From: Nicola Swann [REDACTED]
Sent: 31 July 2019 13:22
To: Planning.Responses <Planning.Responses@arun.gov.uk>
Subject: Pagham responses

- 1.2 P/58/19/PL – Rear of Inglenook Hotel, 253-255 Pagham Road, Pagham PO21 3QB. Erection of 9 No dwellings with associated access, parking, cycle & refuse storage & landscape design. This application is a departure from the Development Plan and may affect the setting of a listed building. **RESOLVED: OBJECT.**
The Parish Council wished to object to the application on the following grounds:

Side Elevation (Unit 7)

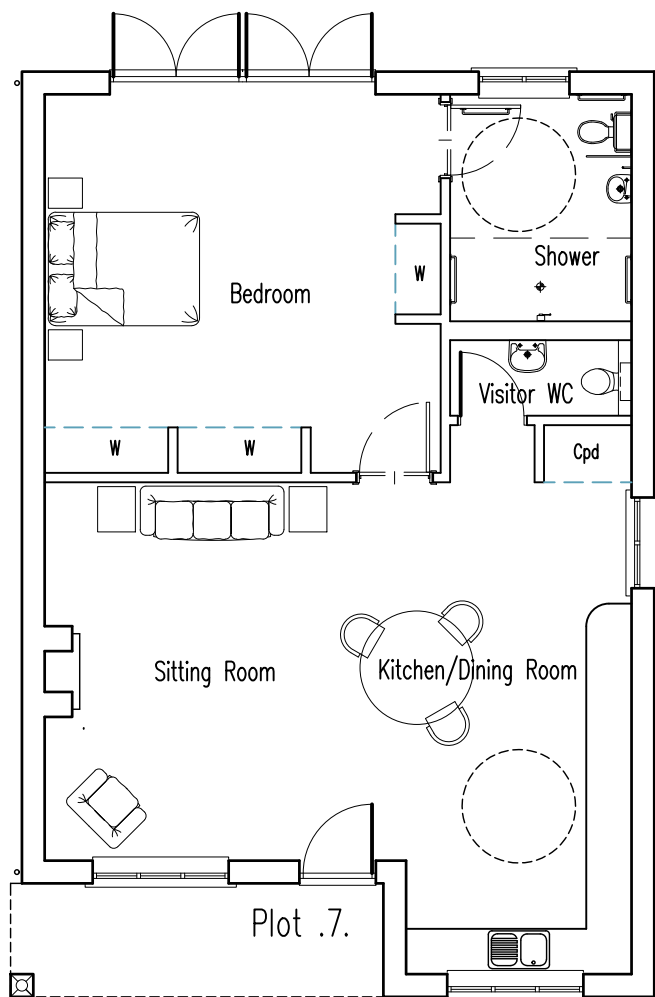
1. The impact on the neighbouring properties at Mill Farm Estate was unacceptable. The development was considered to be unneighbourly and contrary to Policy D DM1 of the Arun Local Plan 2018 para 3 - Have minimal impact to users and occupiers of nearby property and land. For example, by avoiding significant loss of sunlight, privacy and outlook and unacceptable noise and disturbance. This was particularly evident from the scale of Unit 7 and the proximity to the neighbouring Mill Farm Estate properties.
